WELWYN HATFIELD BOROUGH COUNCIL – DEVELOPMENT MANAGEMENT DELEGATED REPORT

APPLICATION No: N6/2013/102/FP

SITE ADDRESS: 157 Parkway, Welwyn Garden City

DESCRIPTION OF DEVELOPMENT: Erection of single storey rear extension, entrance lobby and relocation of existing flank window following demolition of existing outbuildings

DRAWING TITLE
PROPOSED ELEVATIONS

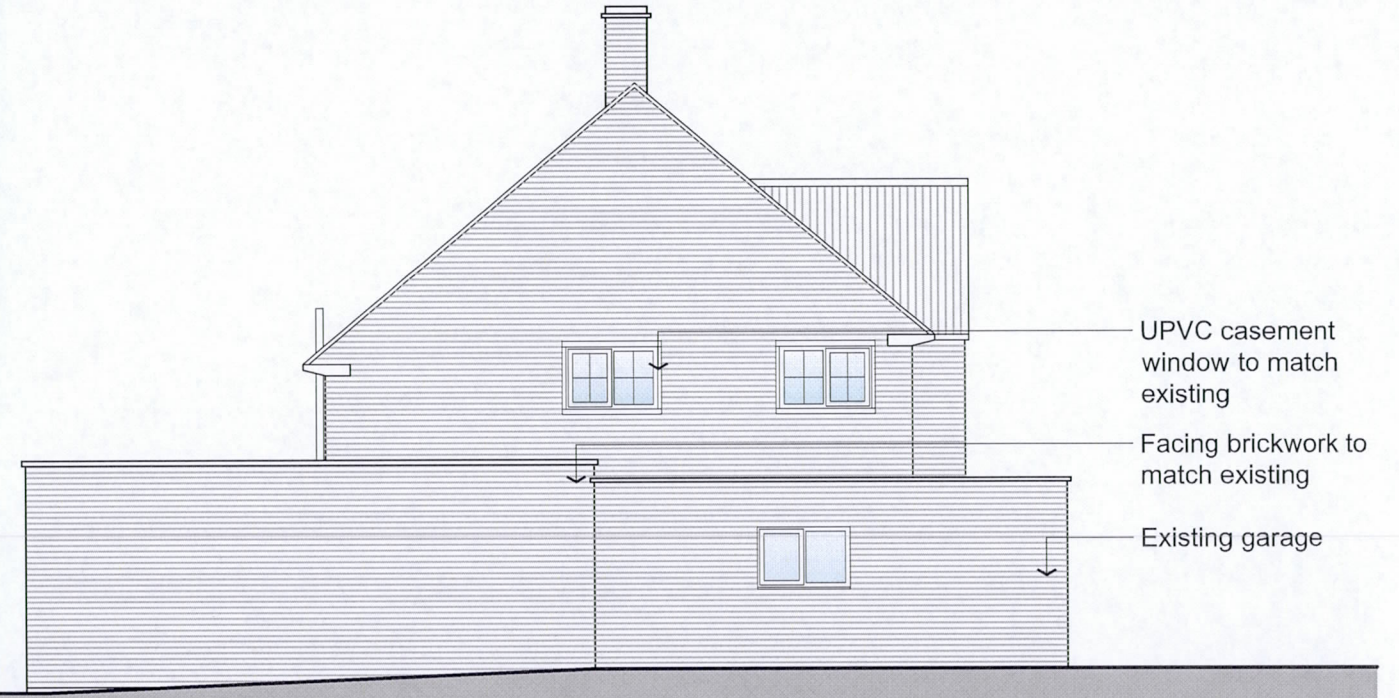
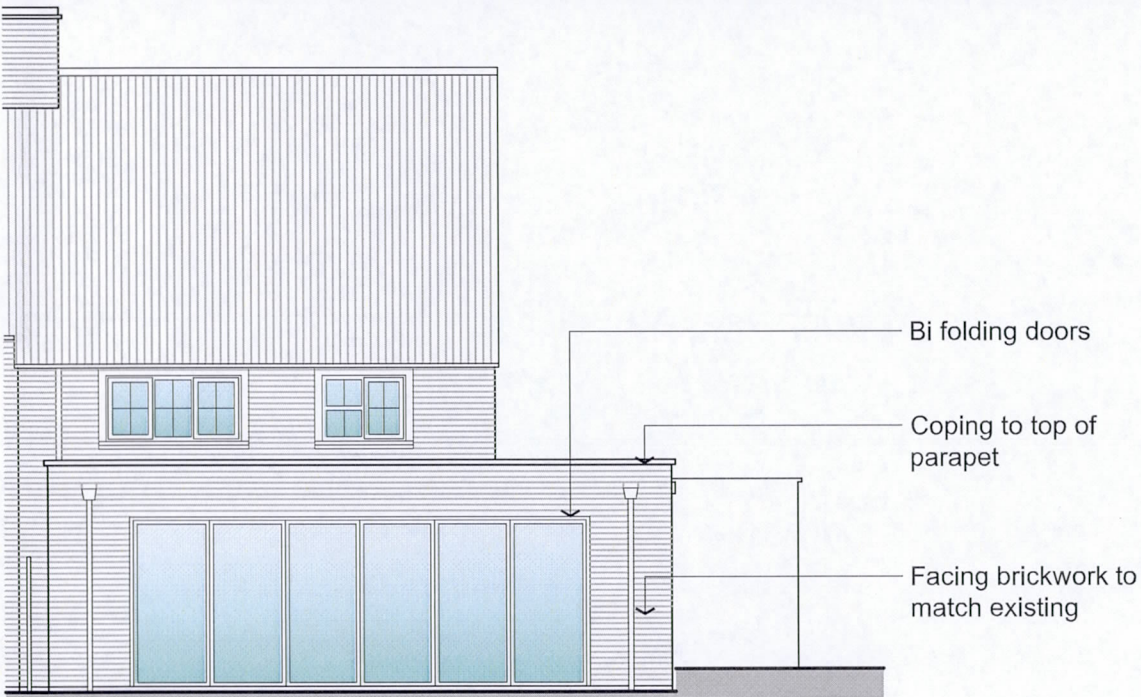
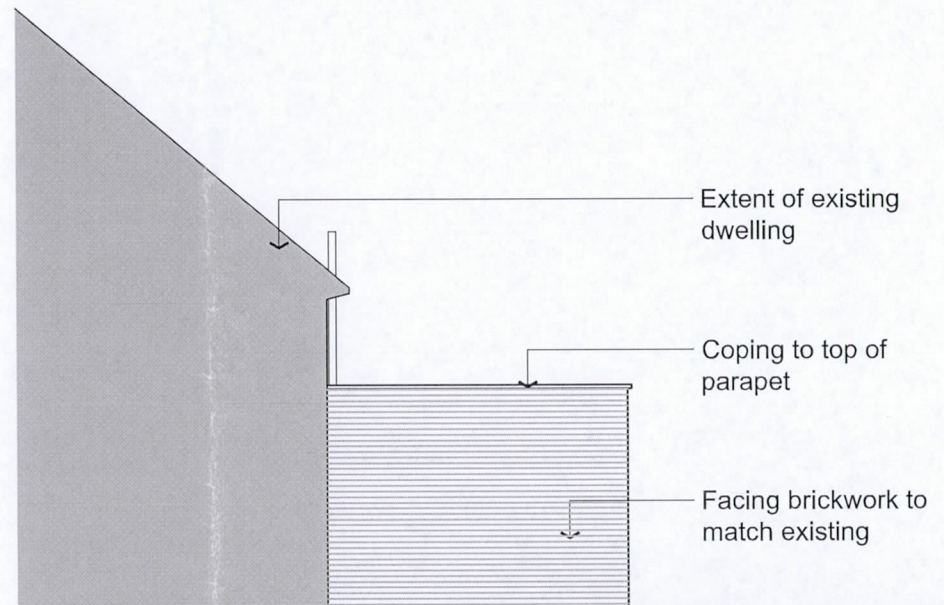
At the front, the creation of the front porch would not introduce discernible additional bulk as it would project the front door forward along an existing enclosed passageway, and whilst slightly taller than existing, this would not be readily discernible given its height to match that of the garage. The porch would not project beyond the forward-most elements of the front elevation of the existing, original, house, and in this regard respects the aims of the SDG in sitting subordinate to it in scale, bulk and mass.

In coming to this conclusion regard is given to the impact of the works on the significance of the conservation area heritage asset in which the site is located and to which its design and character contributes. The height increase of the works behind the garage slightly above the level of its flat roof, and creation of the porch between the existing structures of the house and garage, would both be visible to a limited degree from the street scene of Parkway. Accordingly, in order to secure high quality design as required by policy D1 to a level which sufficiently protects this more vulnerable publically visible element of the heritage asset, a condition requesting material samples to be submitted for approval prior to the commencement of the works is considered both reasonable and necessary to ensure the works respect the appearance of the original house.

DRAWING TITLE
PROPOSED PLANS

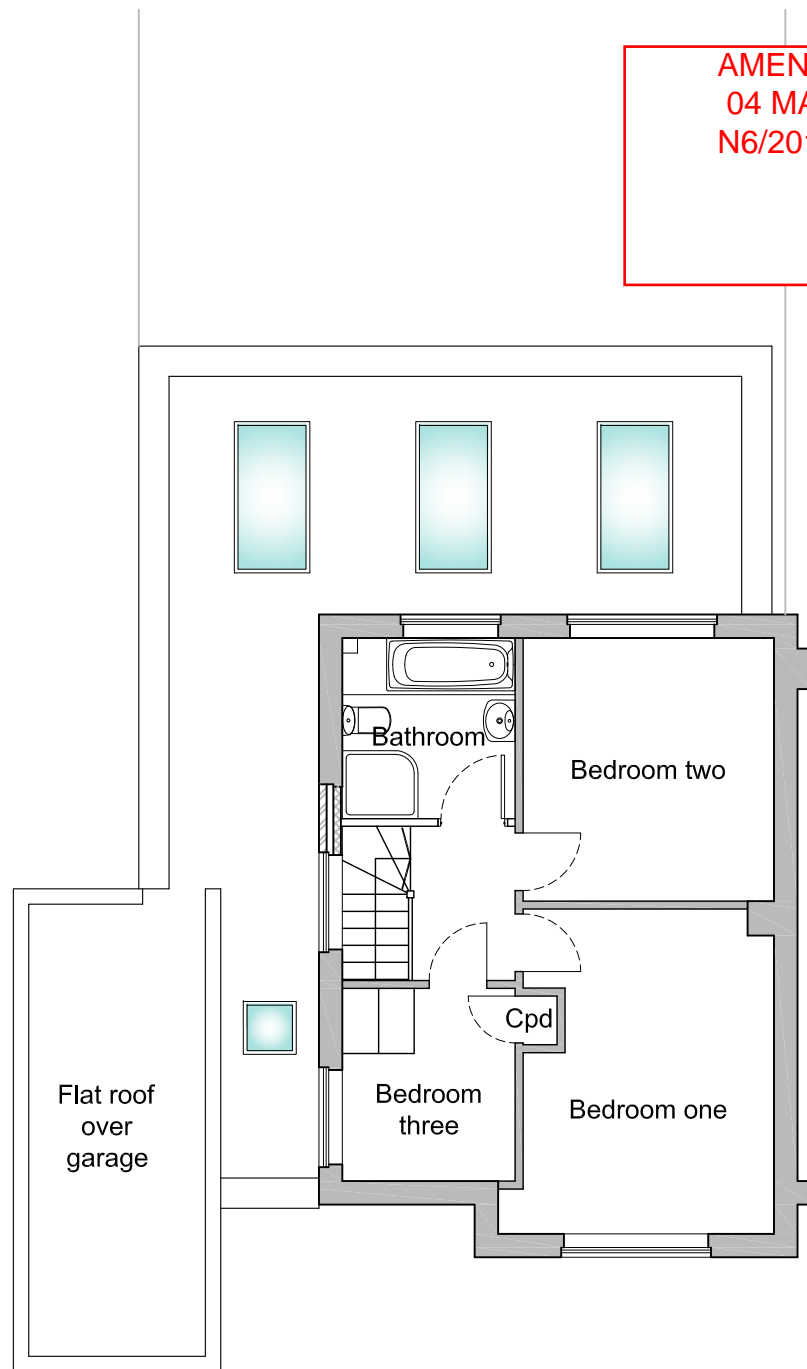
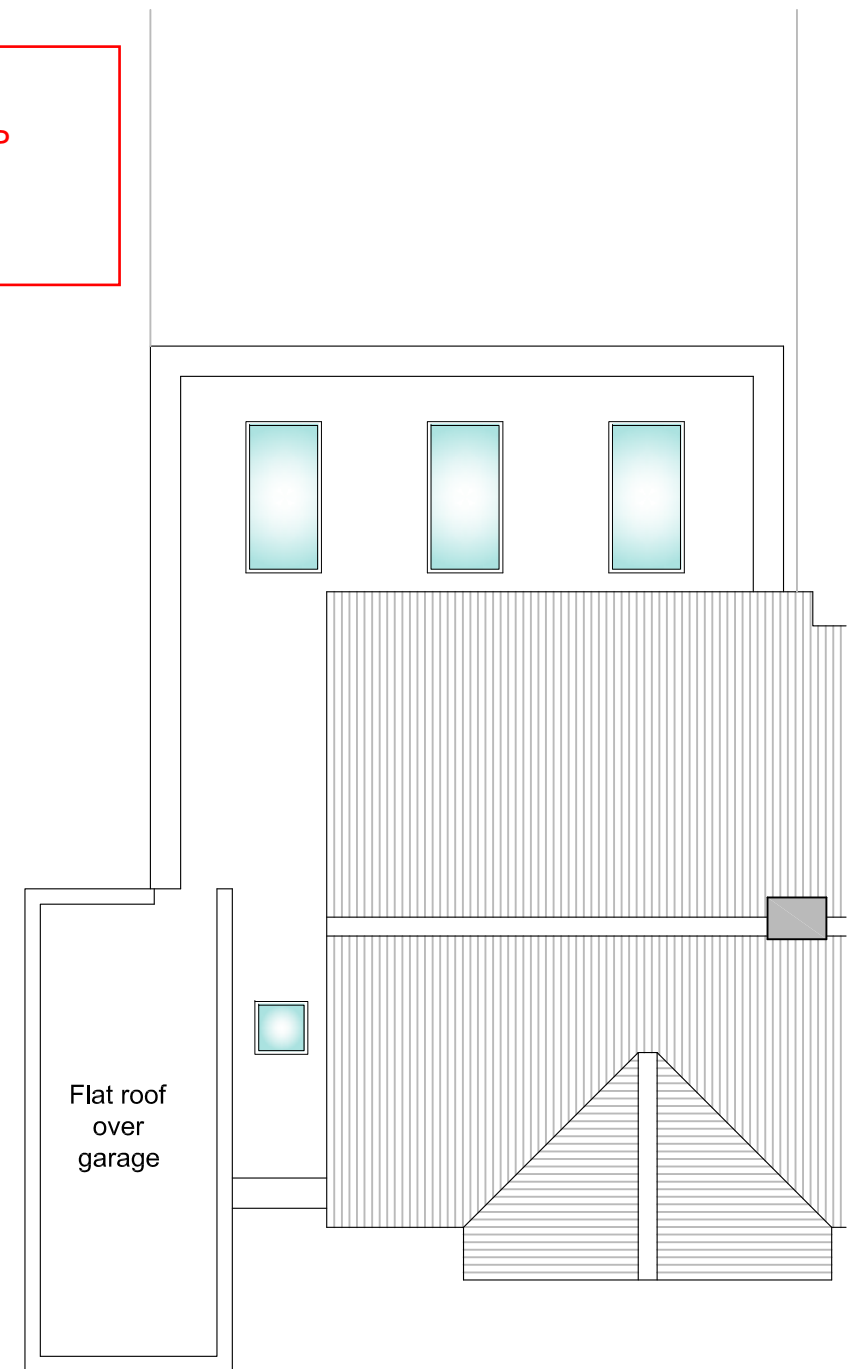
The scale of the works is greater than most single storey extensions, at about 3m. However, they would be set back about 400mm from the boundary with No.159 to the south, and officers have negotiated a reduction in the depth of the rear extension from 4m to 3.5m. Given this depth, the flat roof design of the works, and their setback from the boundary with No.159, whilst large in scale, this is not considered sufficient to cause an overbearing/ over dominant impact, loss of outlook, or reduction in the level of day/sun/sky light to the occupiers of No.159 to a degree sufficient to warrant refusal. No.155 lies about 11m to the north-east of the rear of the existing rear extension, and given its height would increase by about 800mm as a result of the works. Given the similar depth of the additional rear extension proposed which would sit beyond it when viewed from No.155, the works are not considered sufficient in size to result in discernible changes to the amenities of the occupiers of that property or its rear garden with regard to the above considerations to a degree which would warrant refusal. No property faces the site beyond the rear garden. Accordingly, the proposal satisfies policy D1 in this regard.
